**Town of Addison**  
**Summary of Engineering Review Comments**

Date: December 5, 2019  
 Plan Review : Civil Review 2  
 Received: November 13, 2019  
 Plan Date: November 11, 2019  
 Development: Galaxy FBO

Town Project #:19-09D

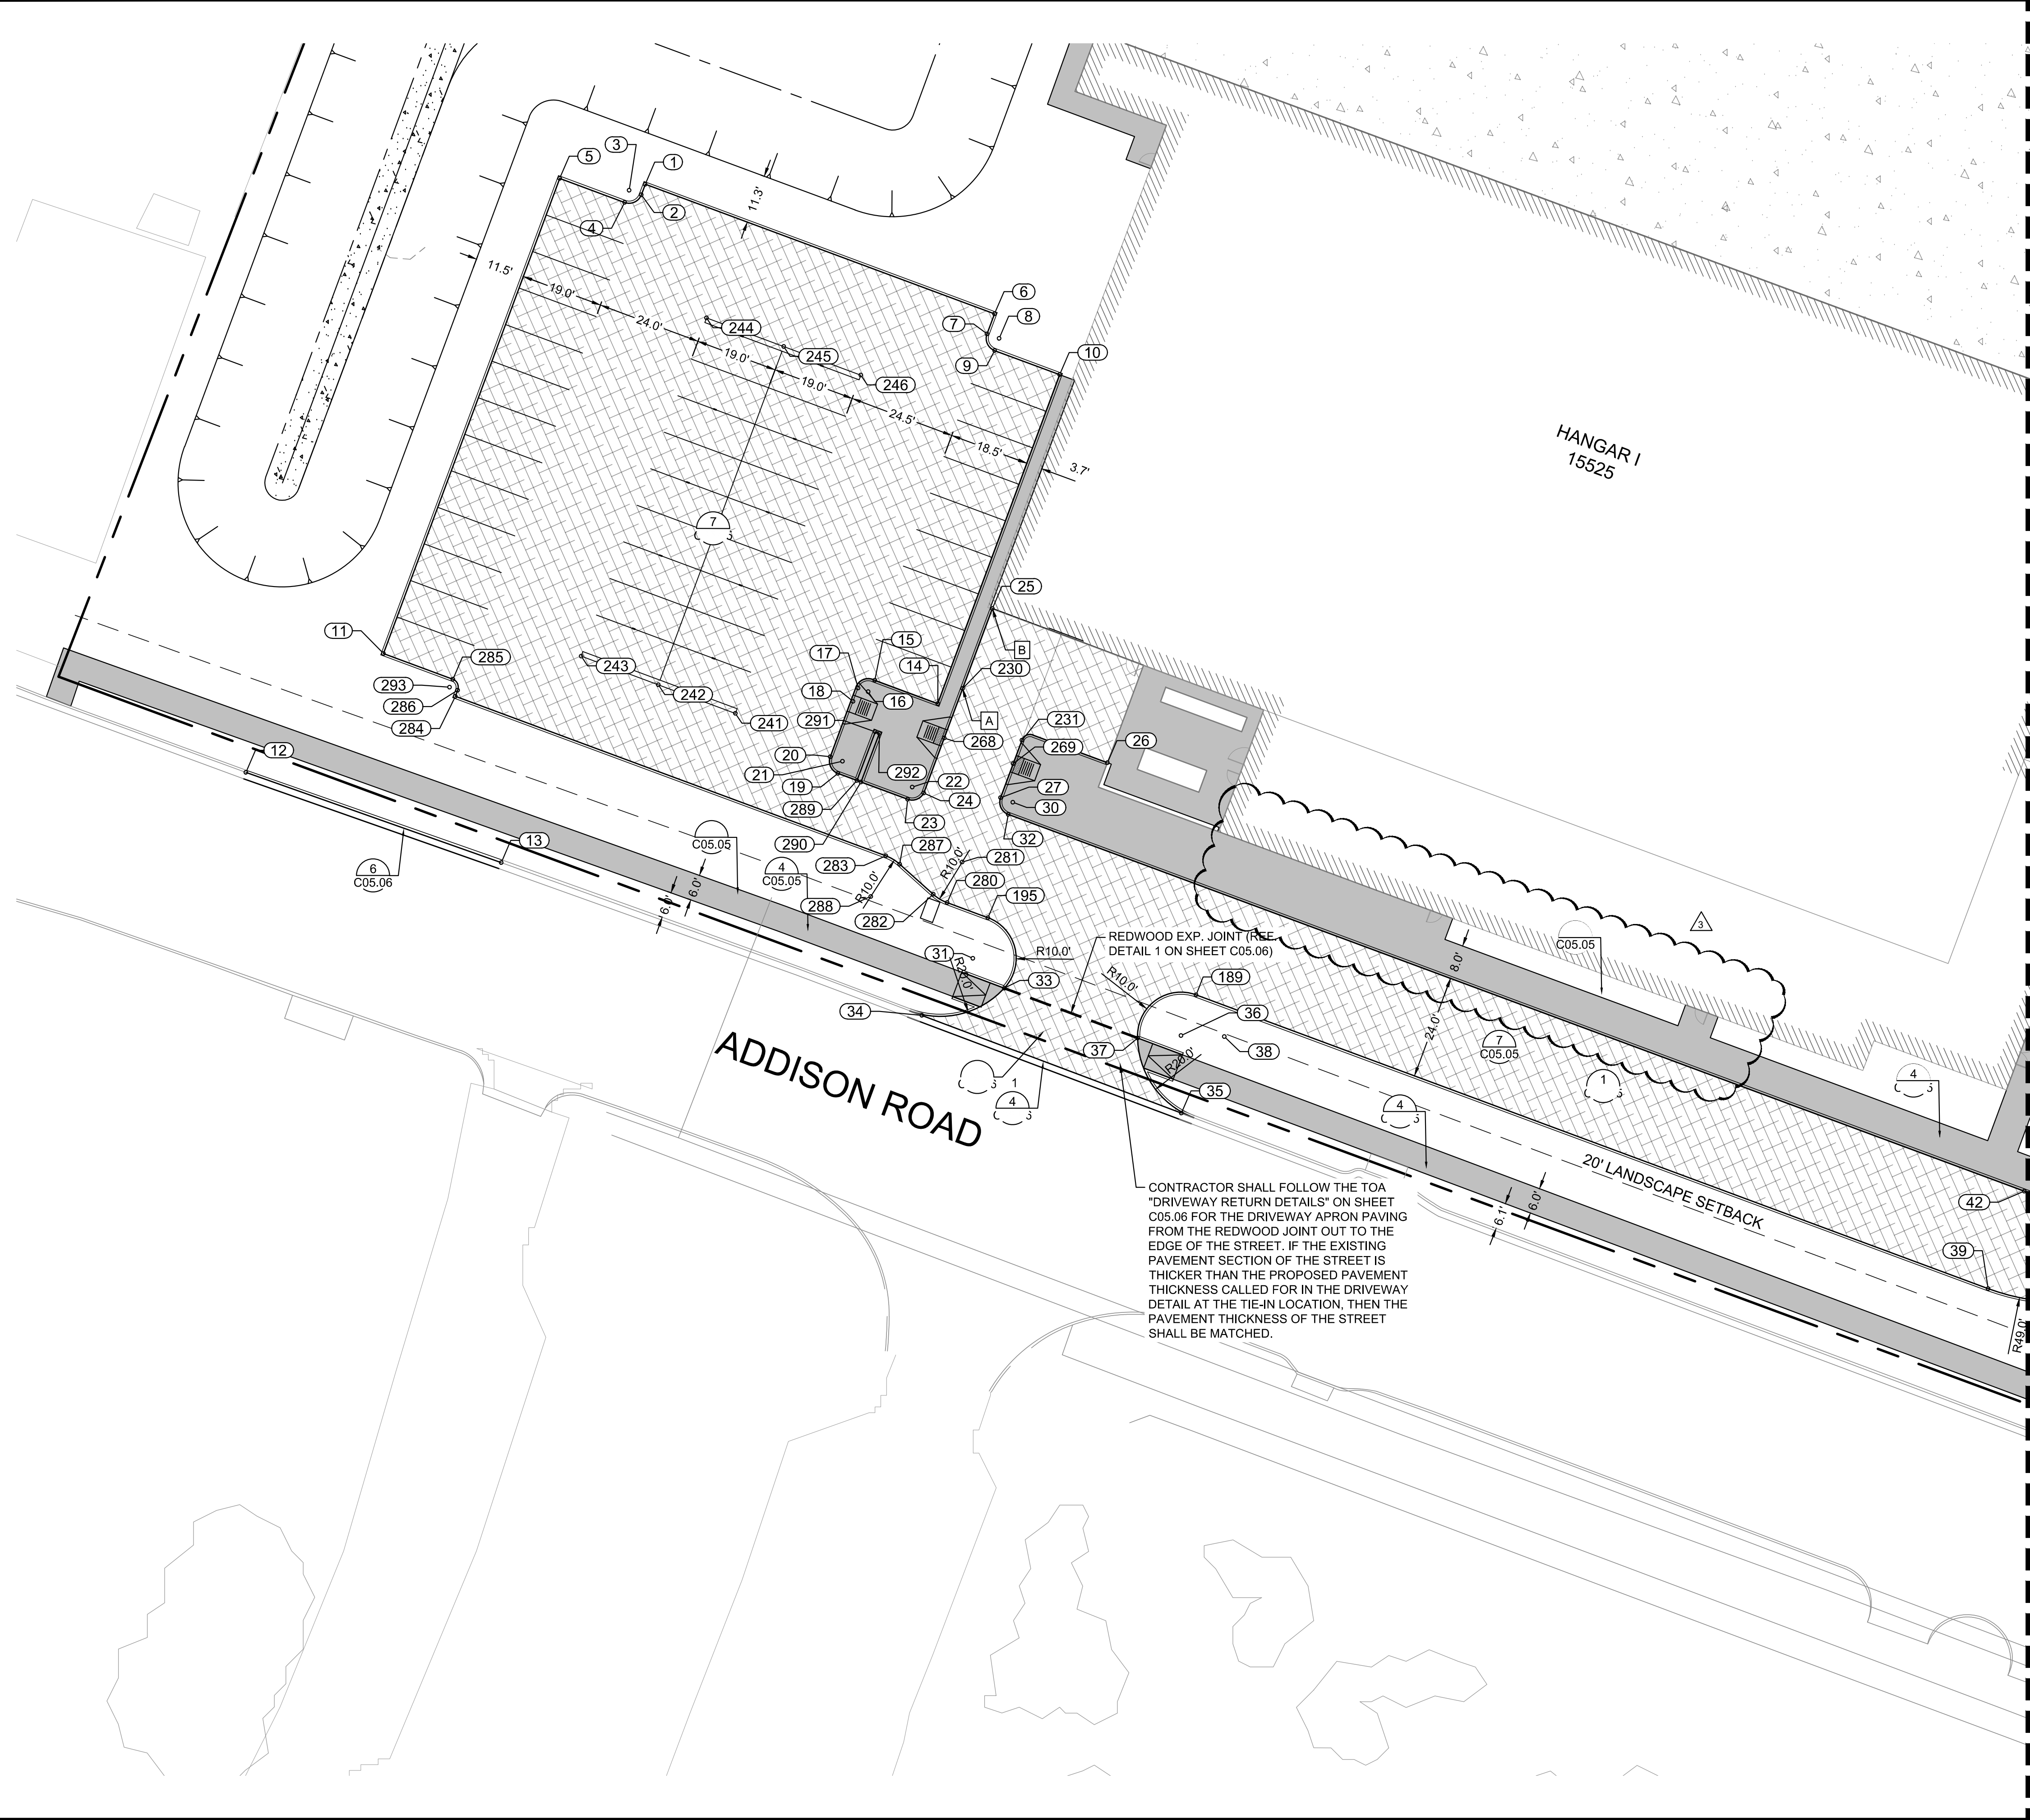
C05.01	Show additional panel replacement for sidewalk on south end.	AGREE	SEE SHEET C05.01 FOR ADDITIONAL SIDEWALK PANEL REPLACEMENT.
C05.05	Add note that panel color shall be determined by the owner (TOA)	AGREE	NOTE HAS BEEN ADDED TO DETAIL ON SHEET C05.05.

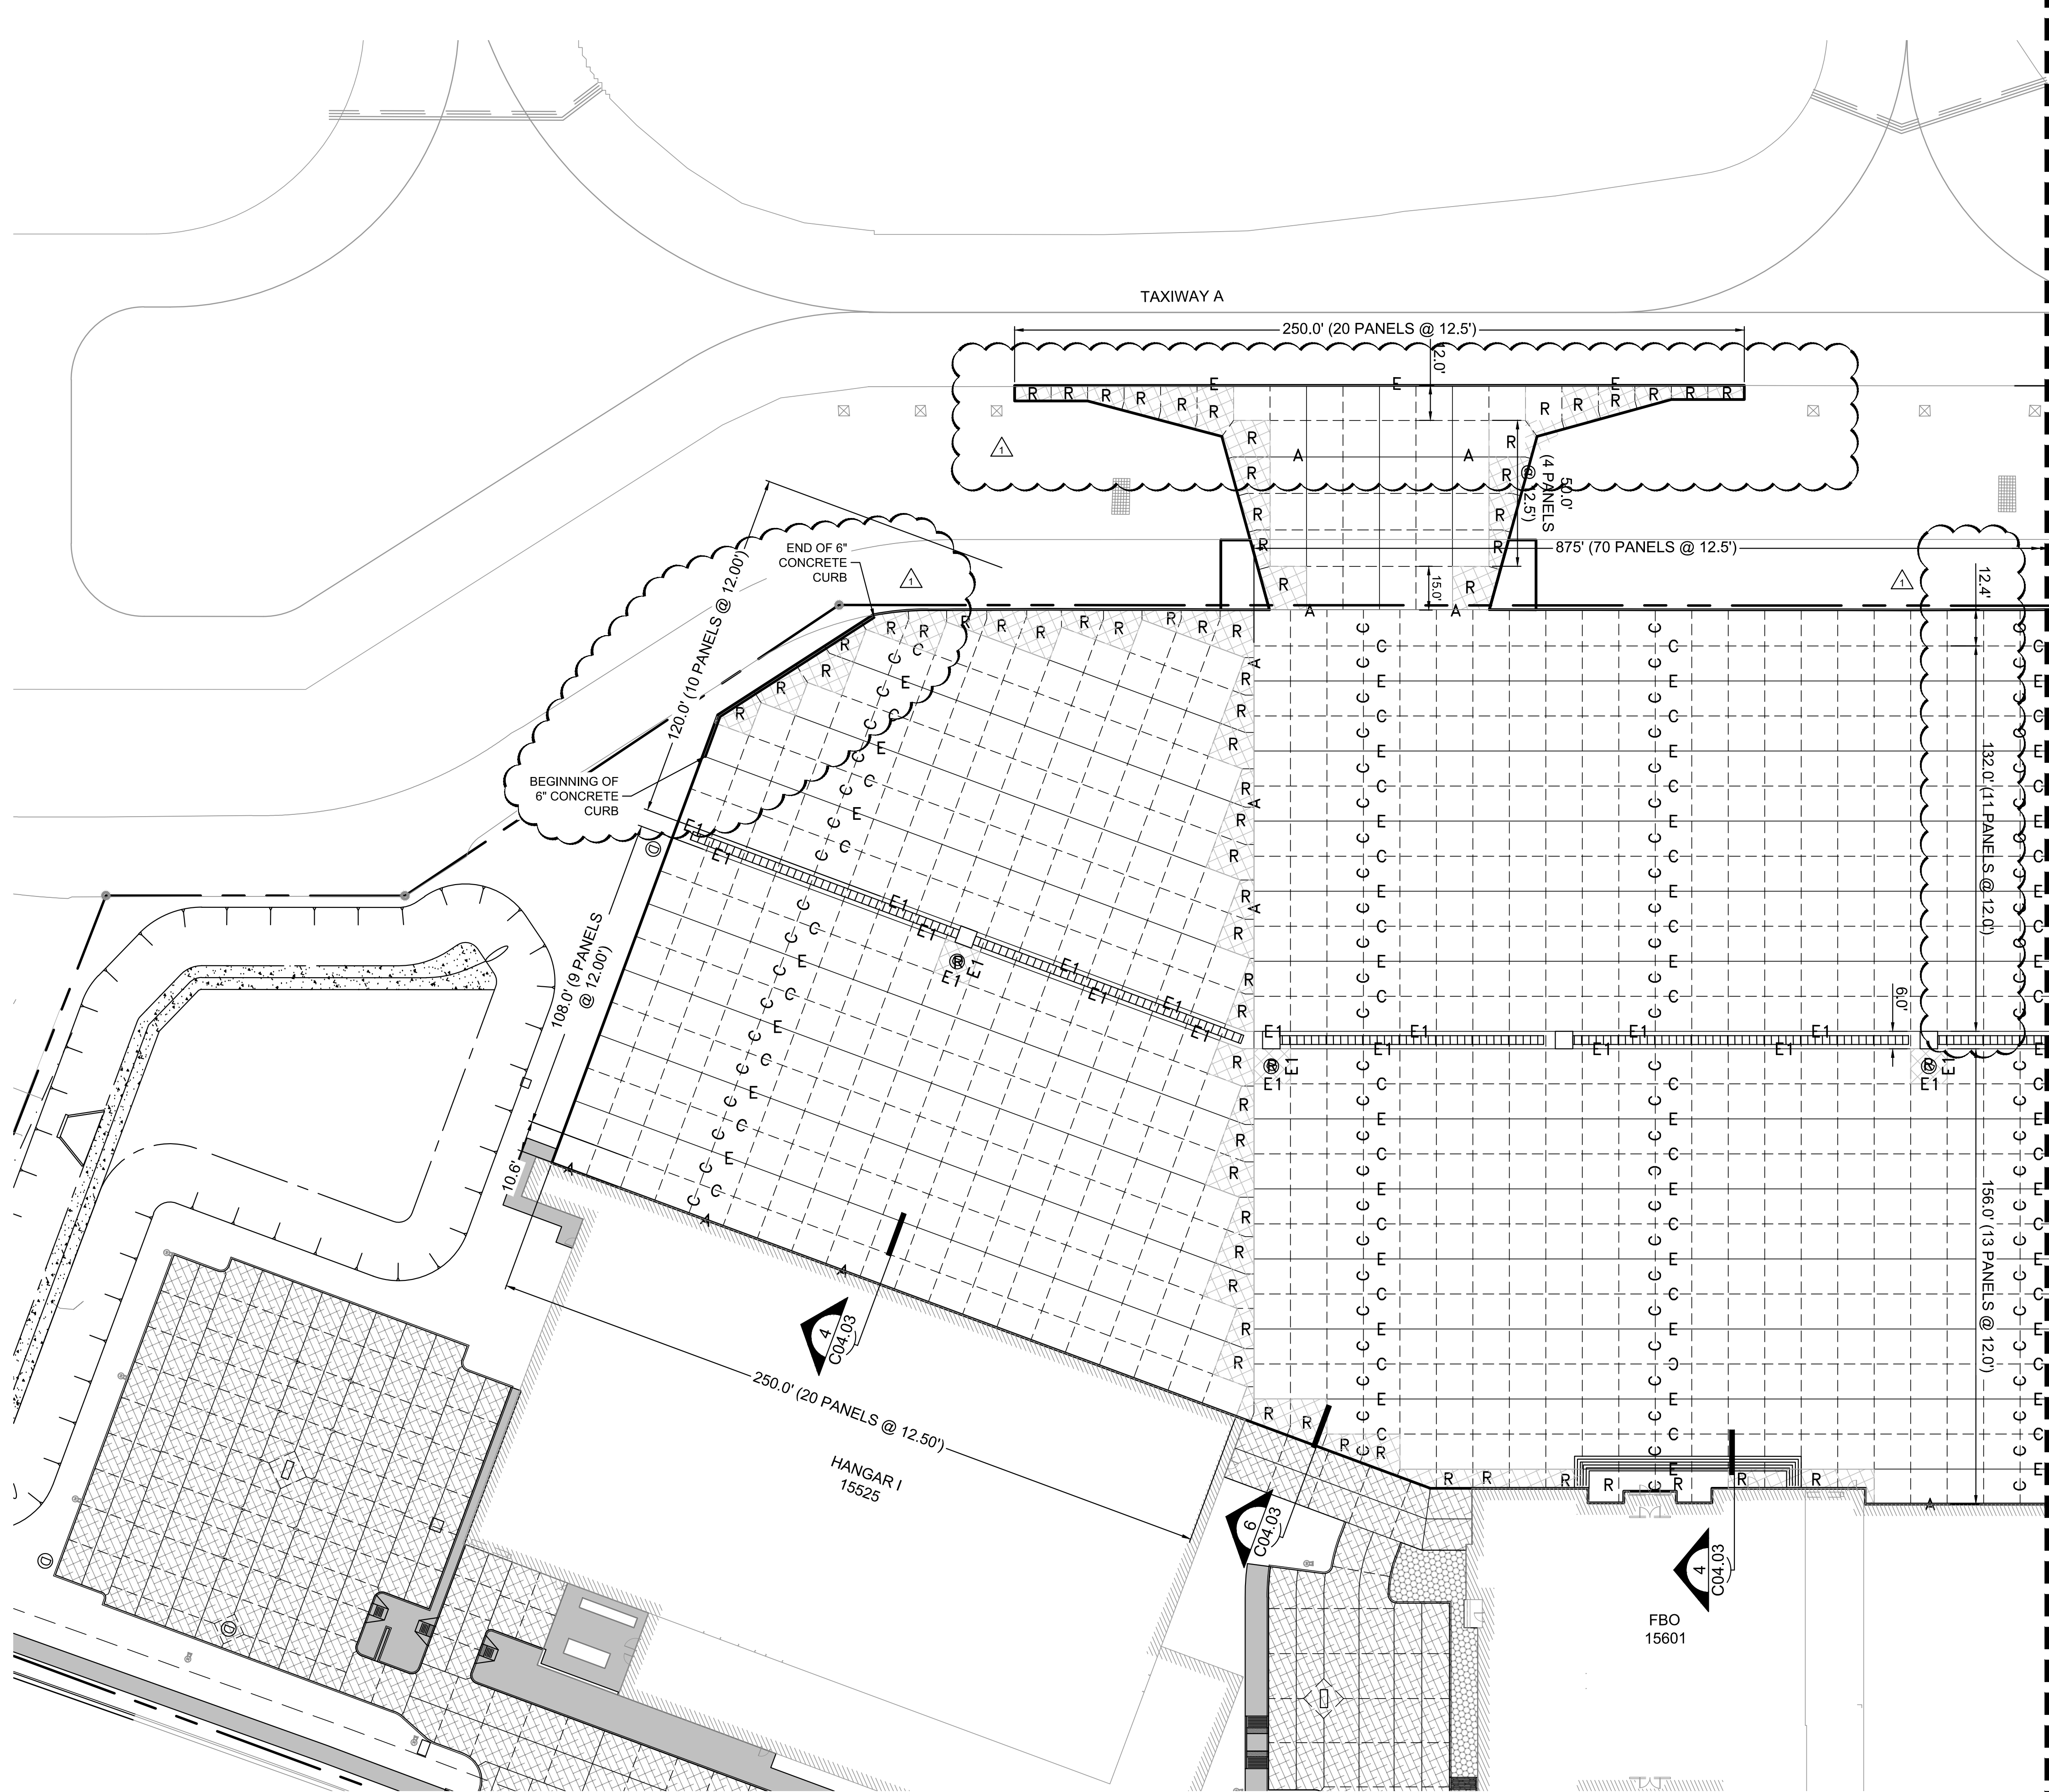
Page No.	Comments	Response (See Note)	Explanation
C06.01	Why aren't you squaring off the taxiway approach so can be poured as one continuous piece rather than multiple separate triangles?	AGREE	THE LEAVEOUT IN THE PERIMETER ROAD COORDINATED WITH GARVER'S DESIGN HAS GOTTEN WIDER, AND THEREFORE, WITH MORE PAVING AREA OF THE PERIMETER ROAD TO BE POURED IN THE SCOPE OF THIS PROJECT, IT IS A SIGNIFICANT ENOUGH COST SAVINGS TO POUR THESE SECTIONS SEPARATELY. THE PERIMETER ROAD PAVING SECTION UP TO THE EDGE OF THE ACTUAL TAXIWAY APPROACH IS A THINNER SECTION THAT MATCHES THE PAVING SECTION IN THE GARVER PLANS.
C06.03	Shouldn't Type A1 under detail 2 also be isolation joint?	AGREE	YES, LABEL HAS BEEN UPDATED TO READ "TYPE A1 REINFORCED EDGE ISOLATION JOINT."
DRAINAGE	<b>PREVIOUSLY REQUESTED.</b> Refer to TOA Drainage Criteria Manual for drainage requirements. <i>Reference storm plan requirement checklists (section 5) and required tables &amp; information as shown in the appendix (Fig 11-15)</i>	AGREE	THE STORM PLAN REQUIREMENTS CHECKLIST, AS WELL AS THE REQUIRED INFORMATION IN FIG. 11-15, HAS BEEN REFERENCED.
